A12 Chelmsford to A120 widening scheme

8.3 Statement of Common Ground with Historic England

Statement of Common Ground with Historic England

Version	Date	Status of Version
P01.1	February 2023	Draft

FIGURE 7.2

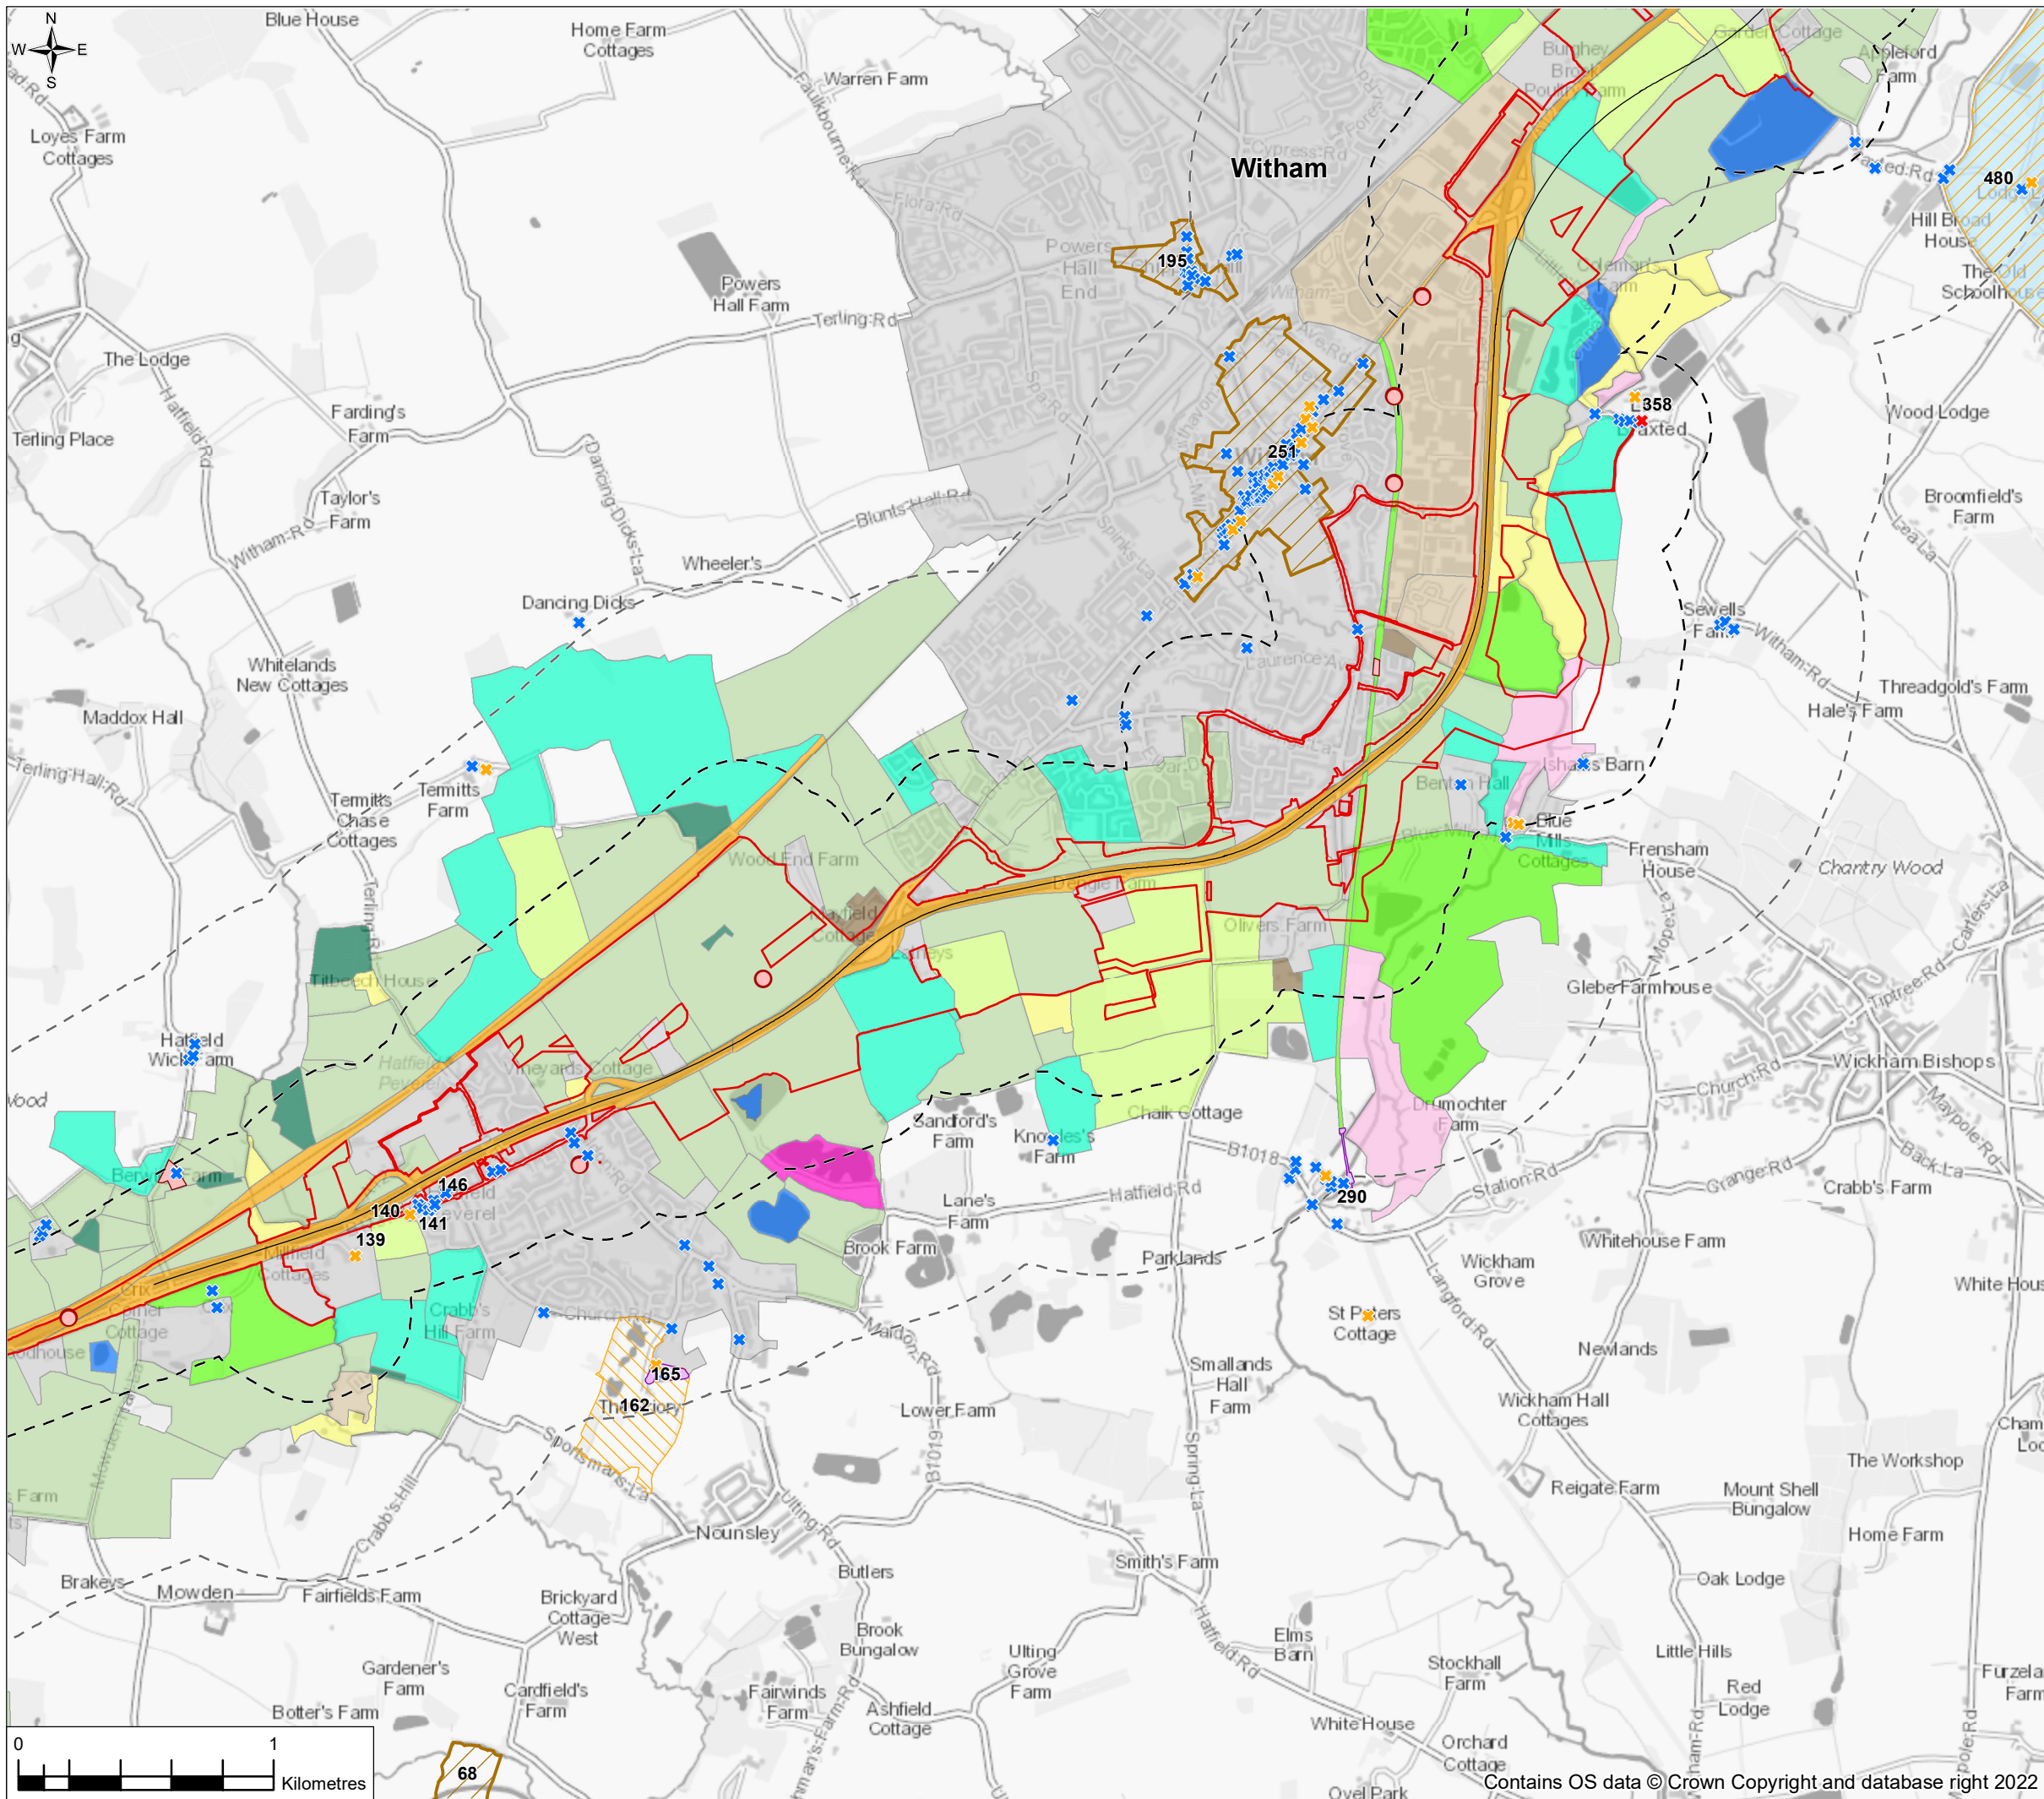
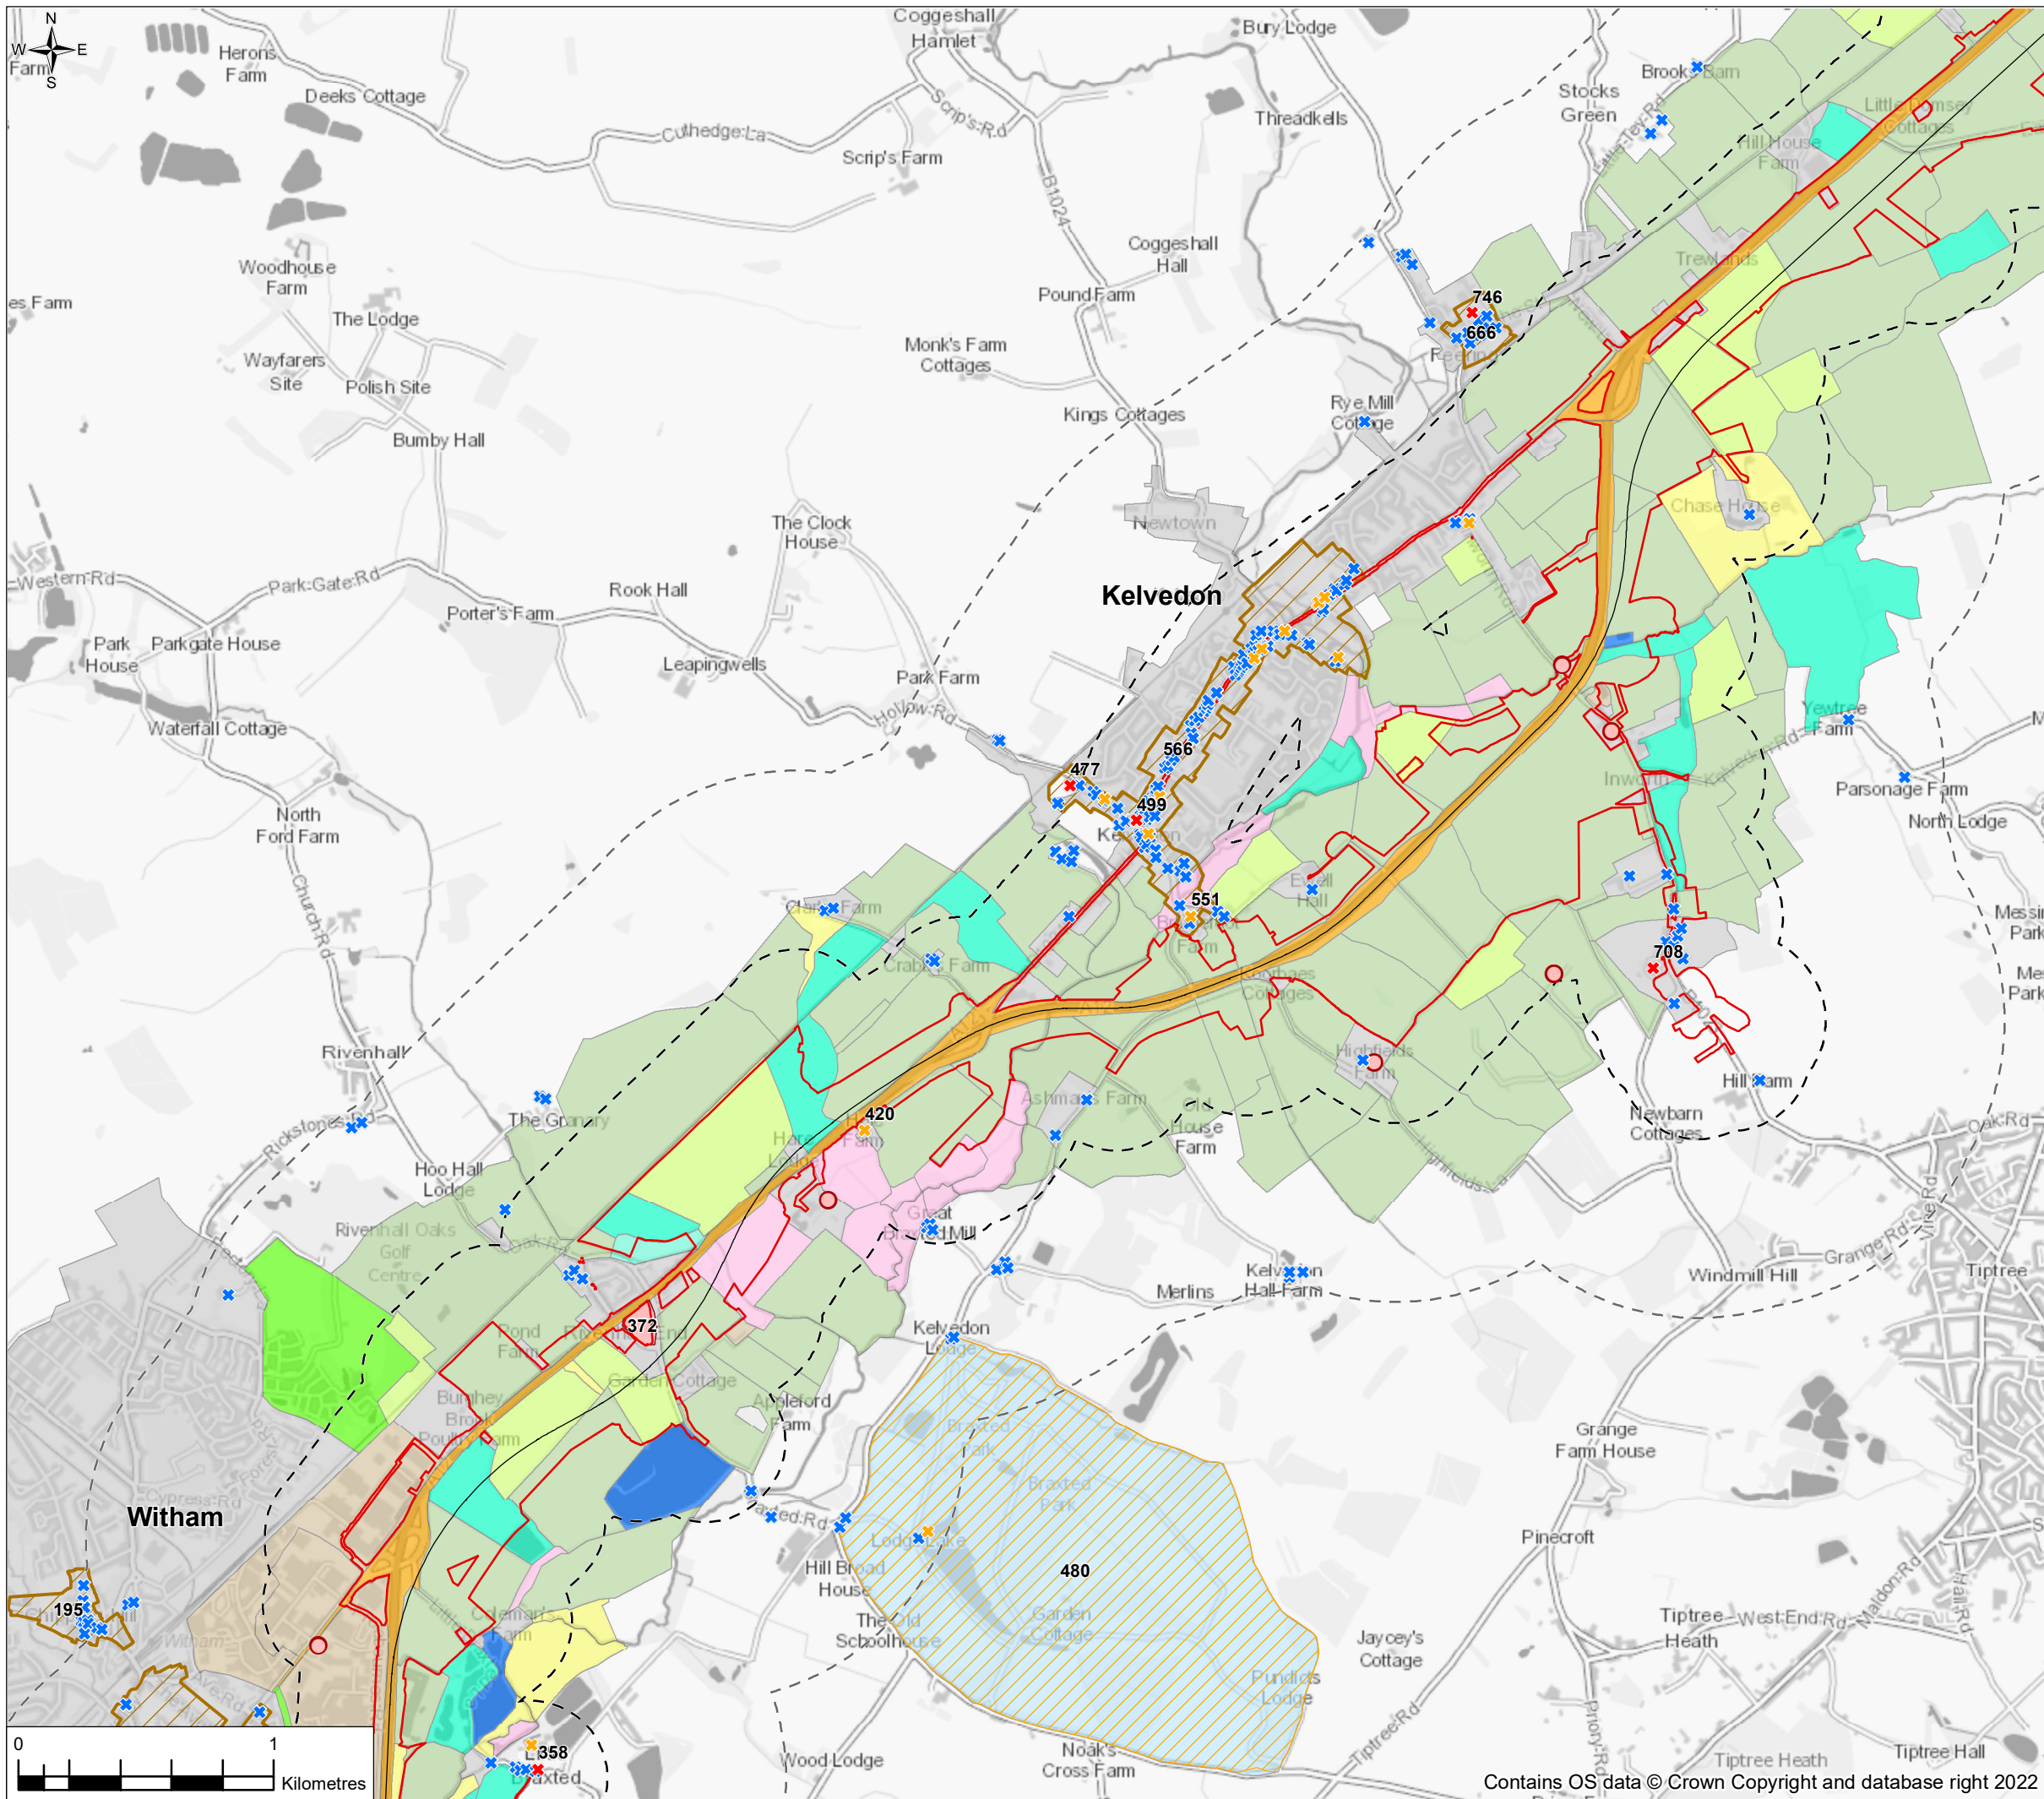
Ref	Issue	Document Reference	Historic England Position	National Highways Position	Status	Date
2.1	Study area for assessment of designated cultural heritage assets	APP-6.1	Historic England stated that the study area for designated heritage assets should extend to 2km based on the preliminary ZTV. If significant effects on the heritage assets beyond 1km are scoped out, this needs to be evidence-based. The assessment study area should be based on the sensitivity of the receiving environment and the potential impacts of the proposed scheme.	A study area extending 1km from the Order Limits has been used to identify designated cultural heritage assets where impacts from the proposed scheme could occur to their setting. Assets have been selected for assessment of potential significant effects on their setting beyond 1km (see Section 7.7 of this chapter) informed by professional judgement guided by the ZTV. Please refer to the ZTV in Figure 8.3 [APP-6.2], which supports the LVIA reported in Chapter 8: Landscape and visual, of the Environmental Statement [APP-6.1].	Under Discussion
